From: Hornby, Mark [Mark.Hornby@lancashire.gov.uk]
Sent: 16 March 2012 15:03
To: Graeme Thorpe
Cc: ENV EPP Customer Service Area East
Subject: FW: Consultation on planning application 3/2012/0086 Old Motor Repair Workshop, Neville Street, Longridge

I have no objection to this proposal, subject to the following conditions:

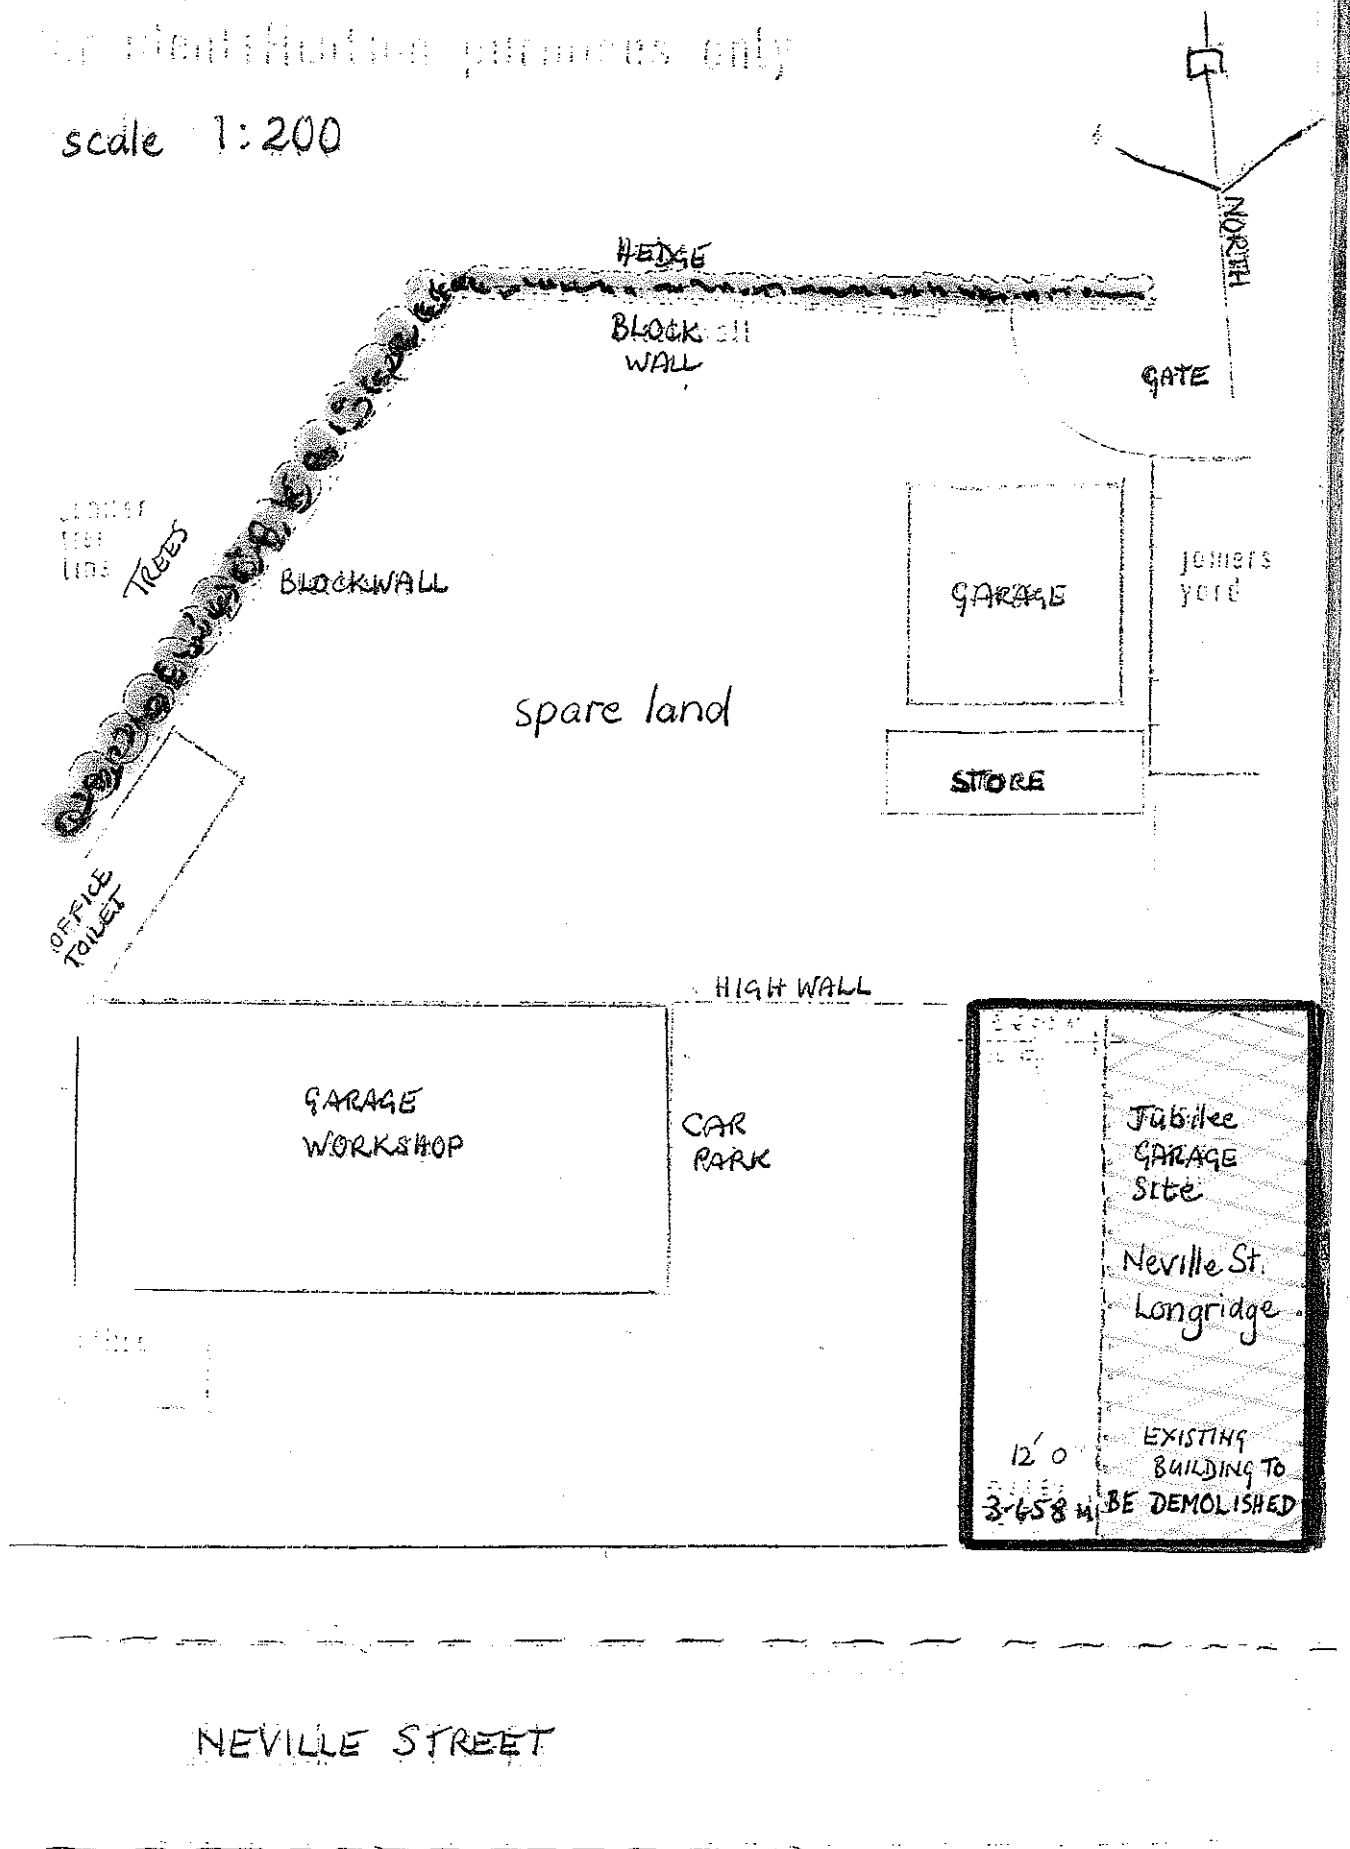
1. The driveway parking area shall extend along the side of the proposed dwelling in order to provide sufficient space for two vehicles. Reason: To reduce the likelihood of additional on street parking in the interests of highway safety.

2. Before the access is used for vehicular purposes, any gateposts erected at the access shall be positioned 5 metres behind the nearside edge of the carriageway. The gates shall open away from the highway. Reason: To permit vehicles to pull clear of the carriageway when entering the site.

3. Before the access is used for vehicular purposes, that part of the access extending from the highway boundary for a minimum distance of 5 metres into the site shall be appropriately paved in tarmacadam, concrete, block pavements, or other approved materials. Reason: To prevent loose surface material from being carried onto the public highway thus causing a potential source of danger to other road users.
